Application number: 2025/93543	
What is the application for?:	Erection of 33 dwellings (c3) with access from Clough Road and associated works
Address of the site or building:	land at, former Clough Mill, Clough Road, Slaithwaite, Huddersfield, HD7 5DB
Postcode:	HD7 5AL

Type of comment: An objection	
Do you wish your comments to be published on the website anonymously?	Yes

Visibility Splay Drawings

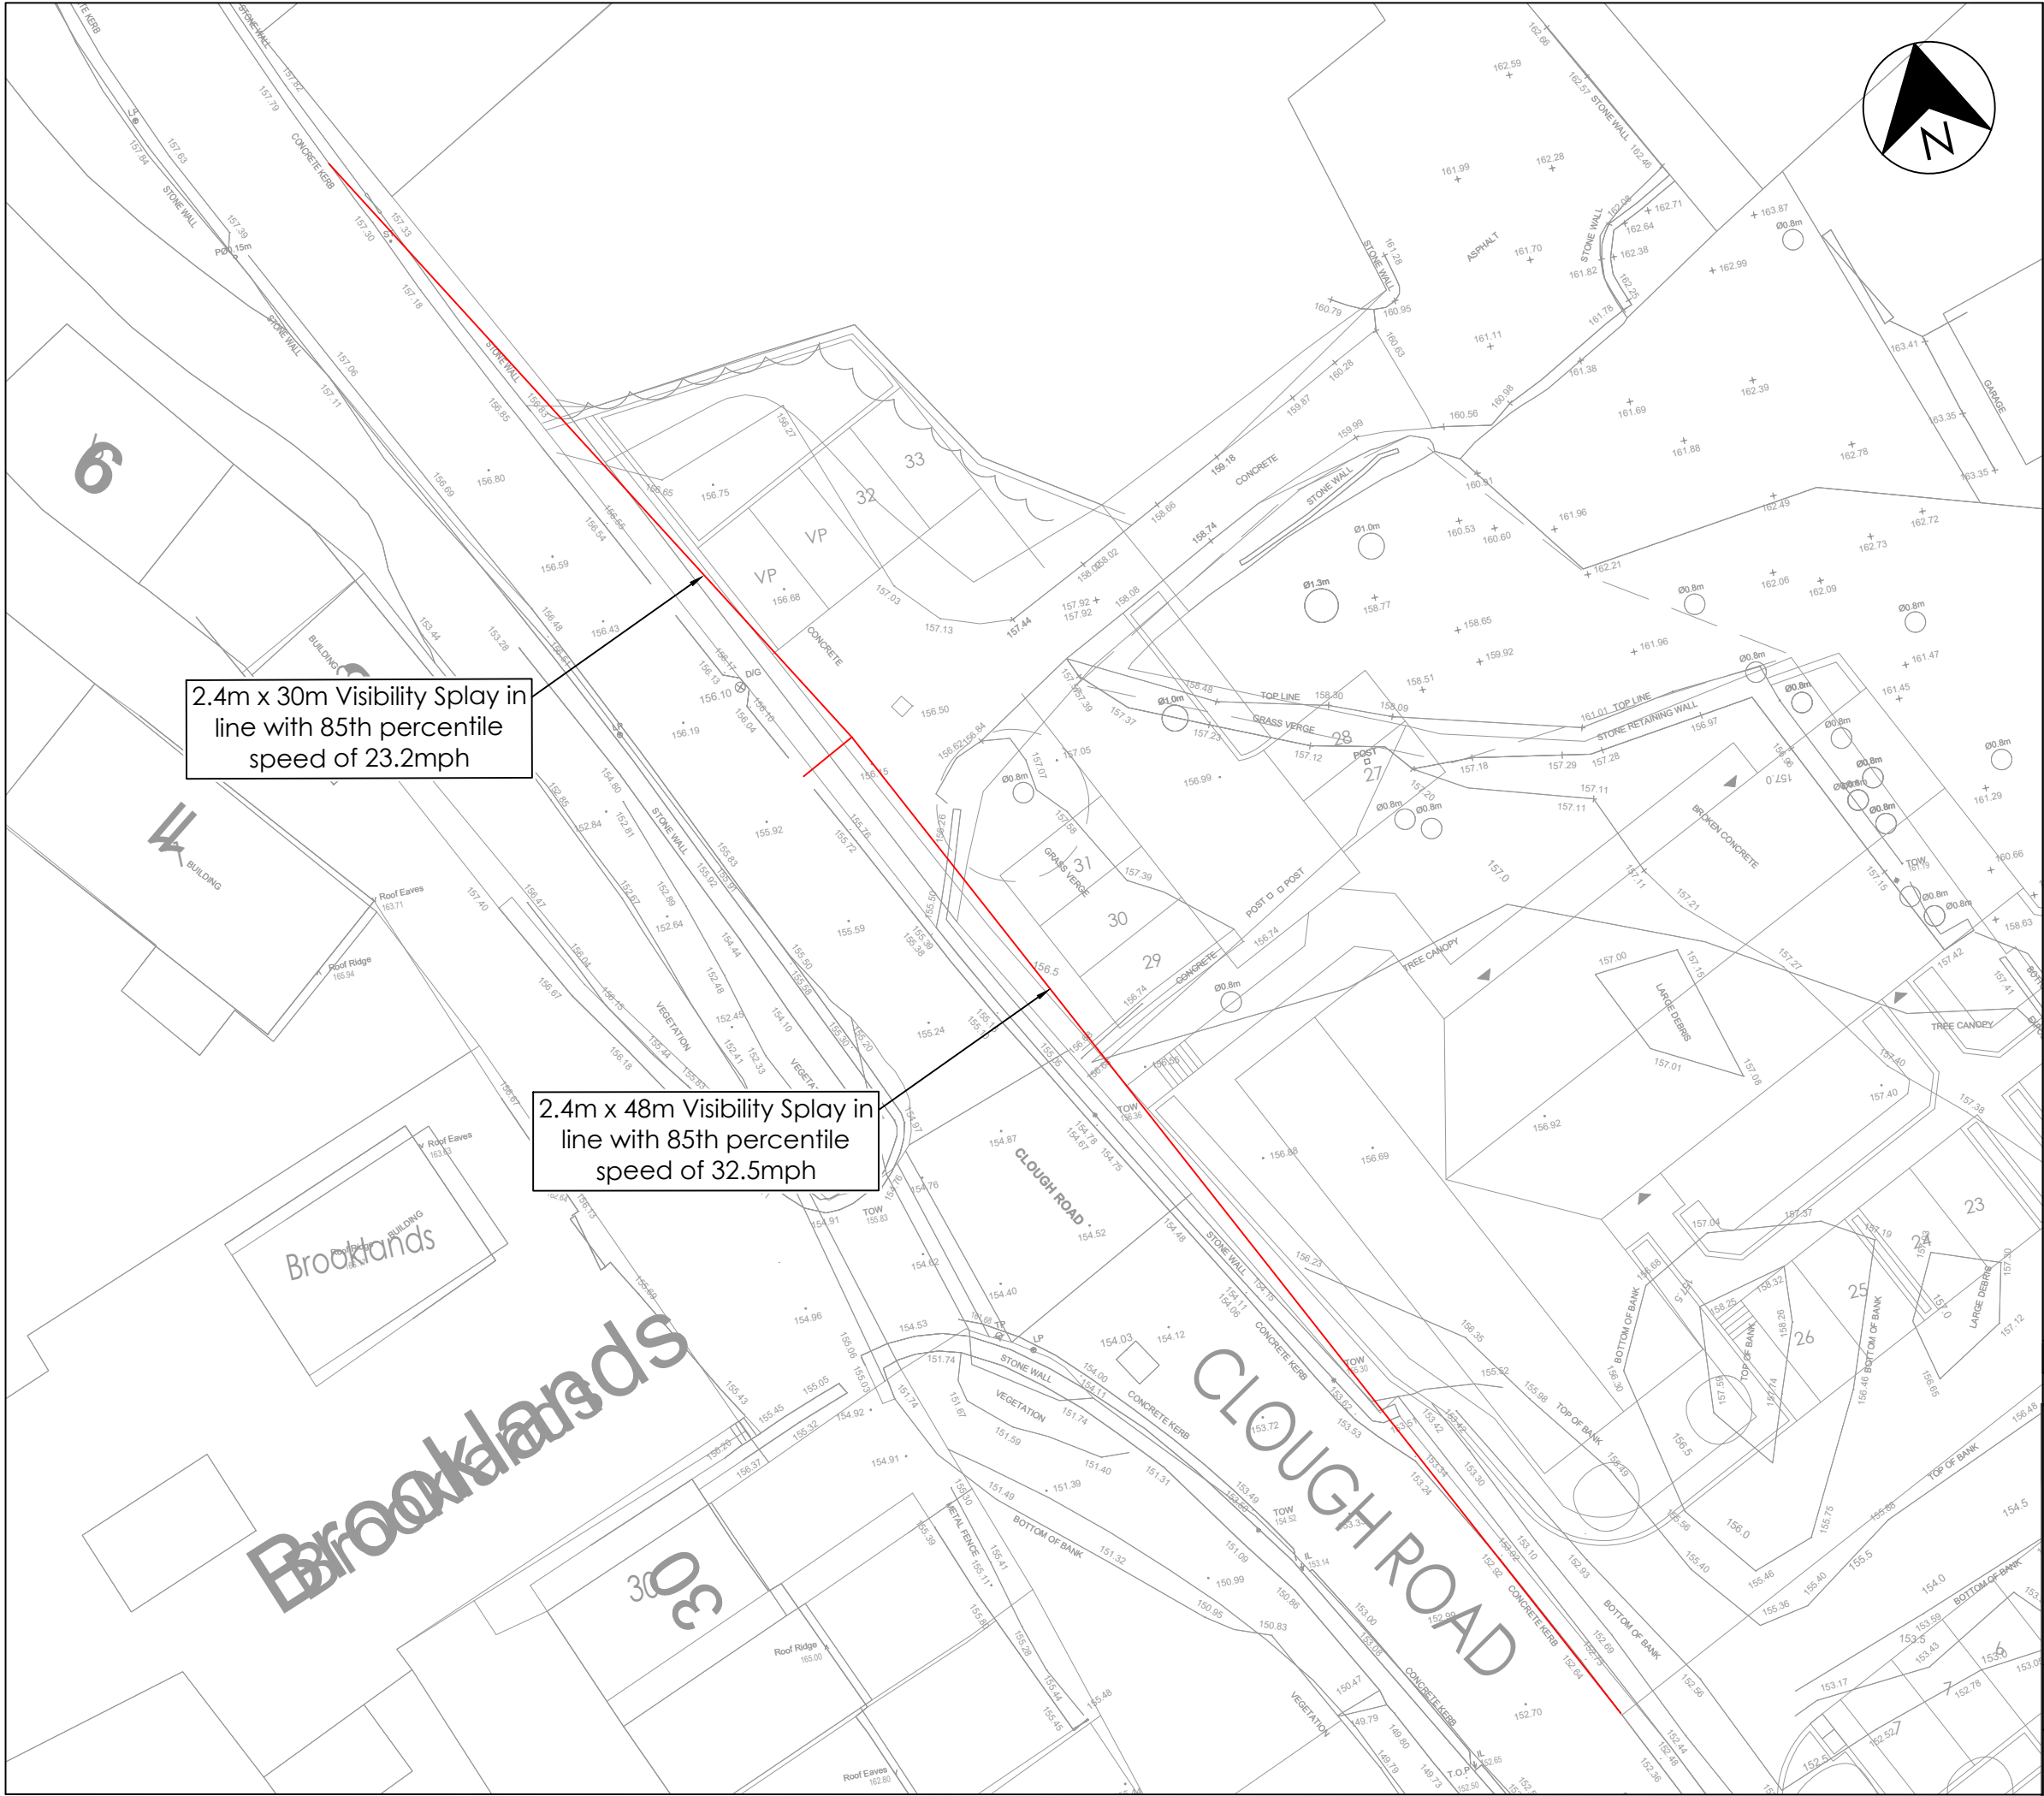
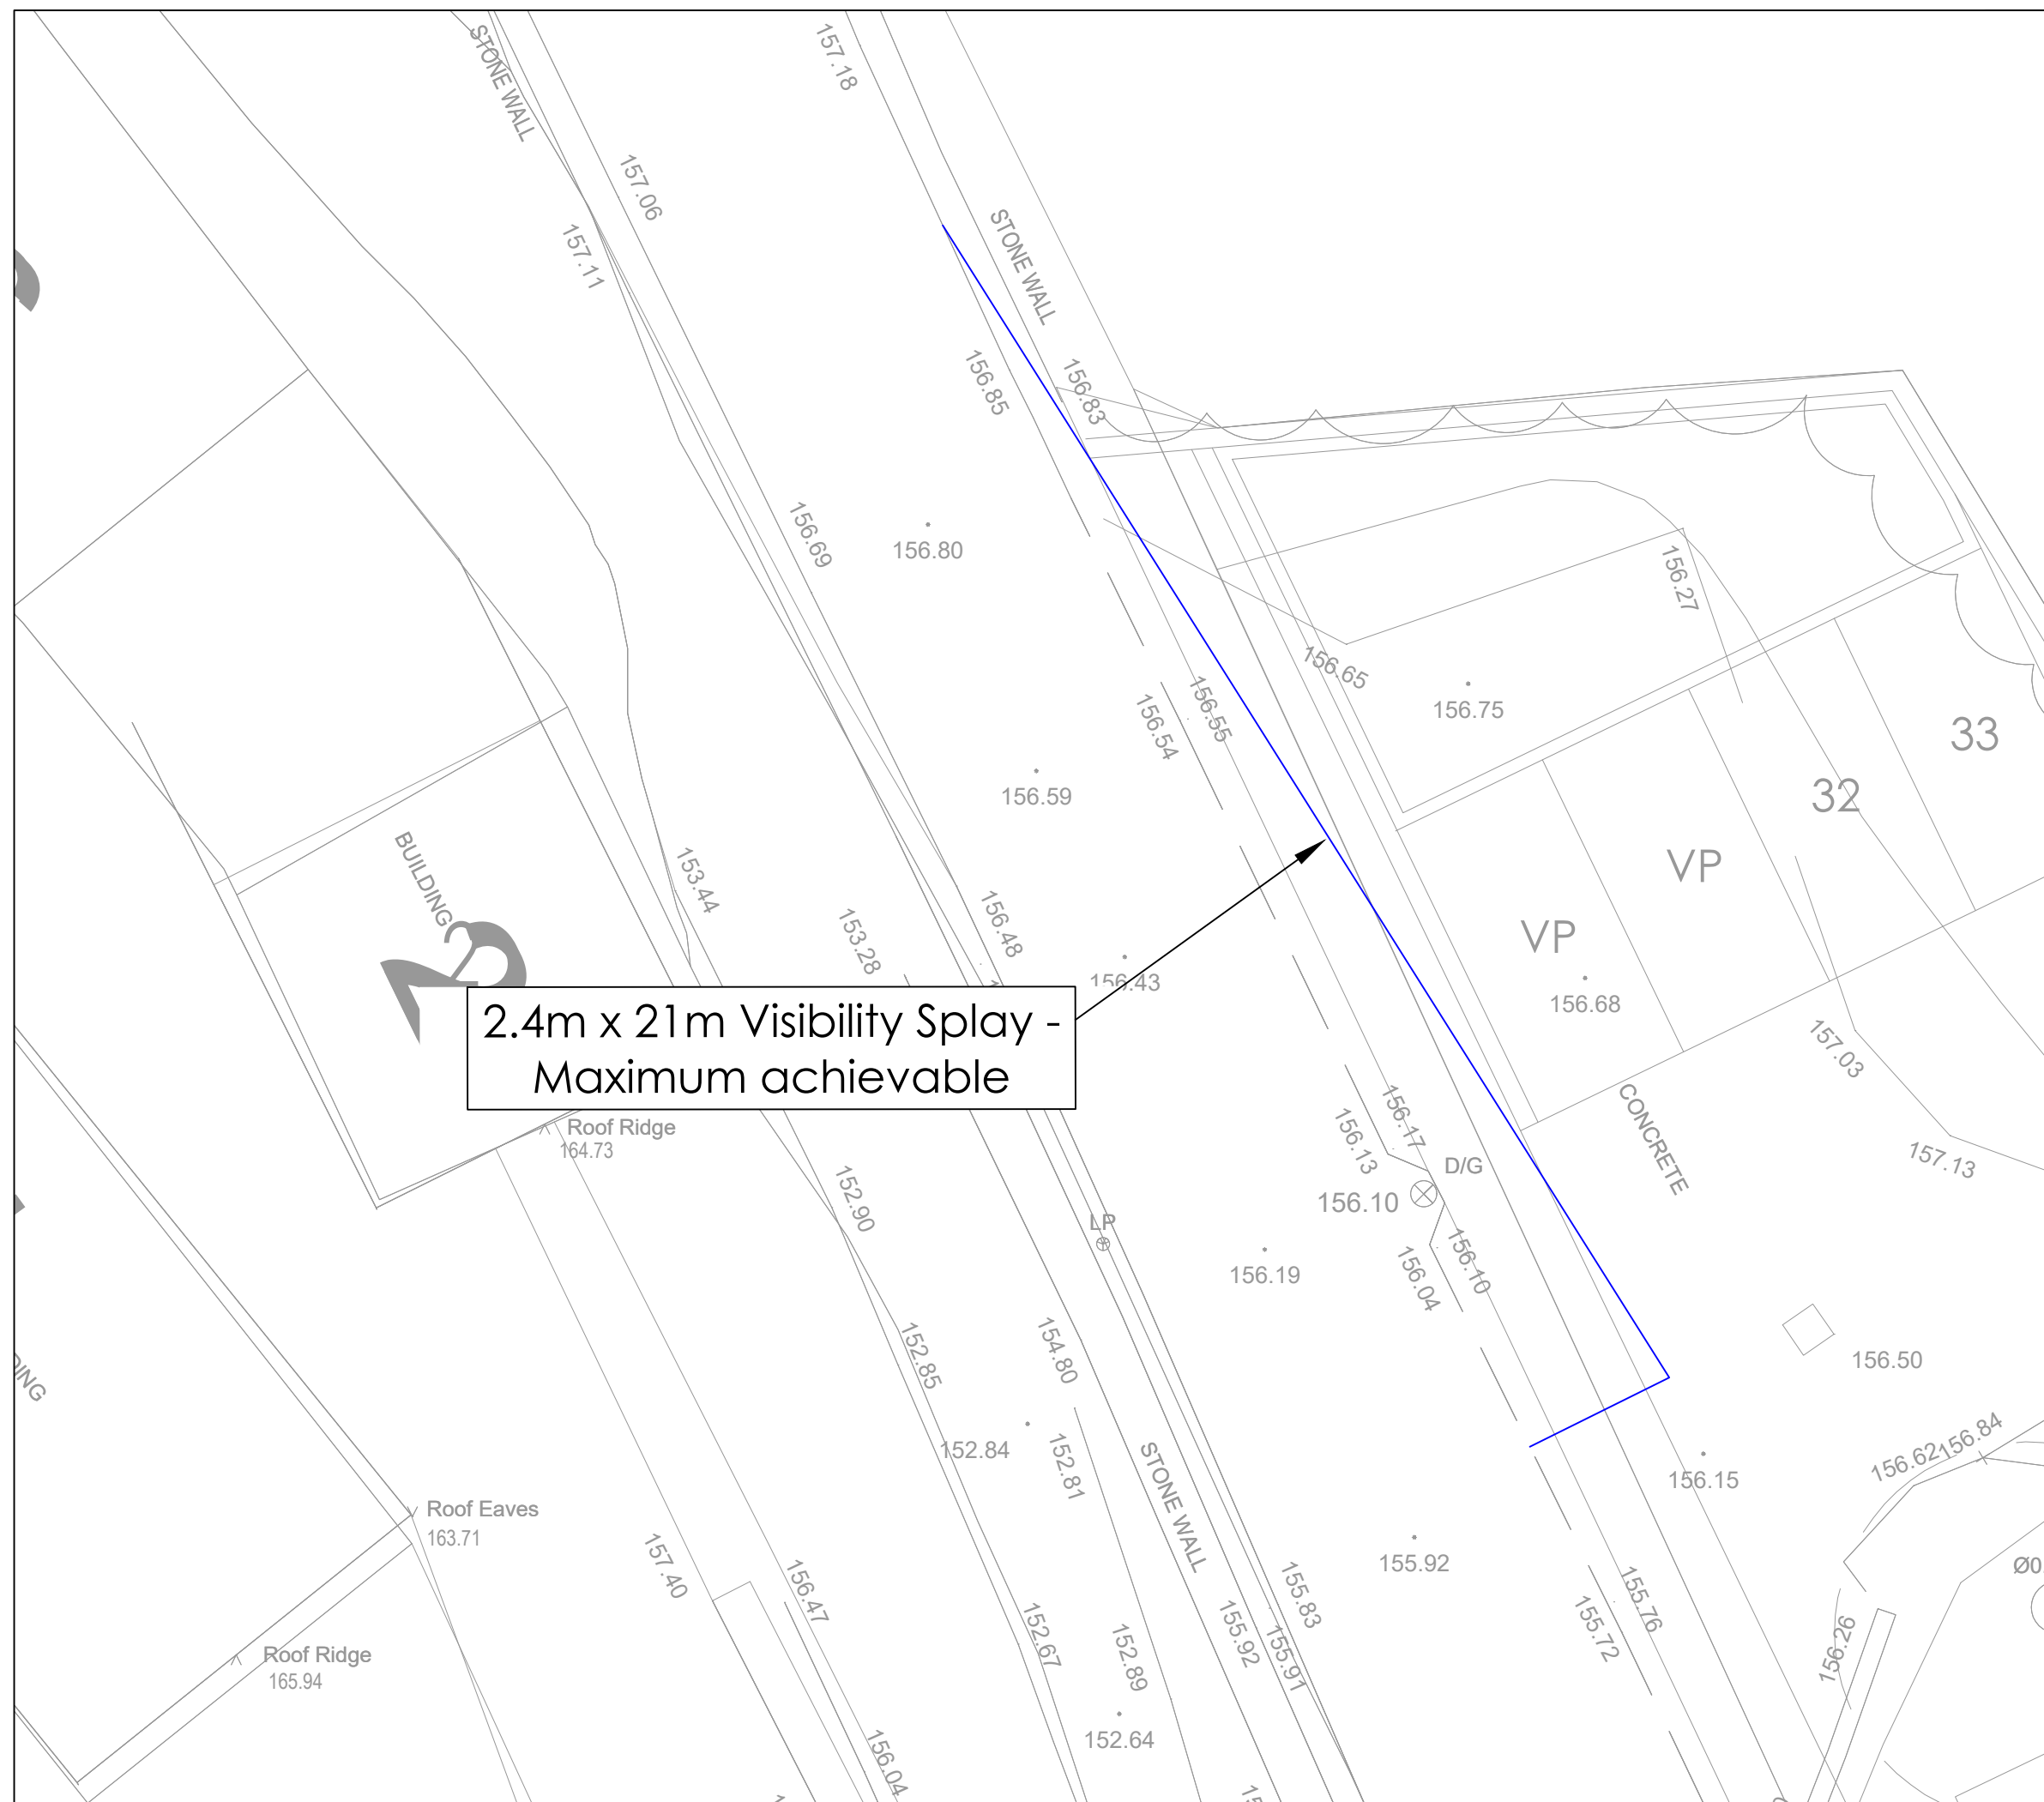
Road Safety and Access: Clough Road is a busy main road that regularly backs up at a hairpin to the north. The proposed access junction sits at the road's narrowest point, where two vehicles frequently cannot pass. The Transport Assessment neither models whether this junction is workable nor addresses how turning movements will be safely managed. Traffic figures also appear to underestimate the impact of the proposed number of homes.
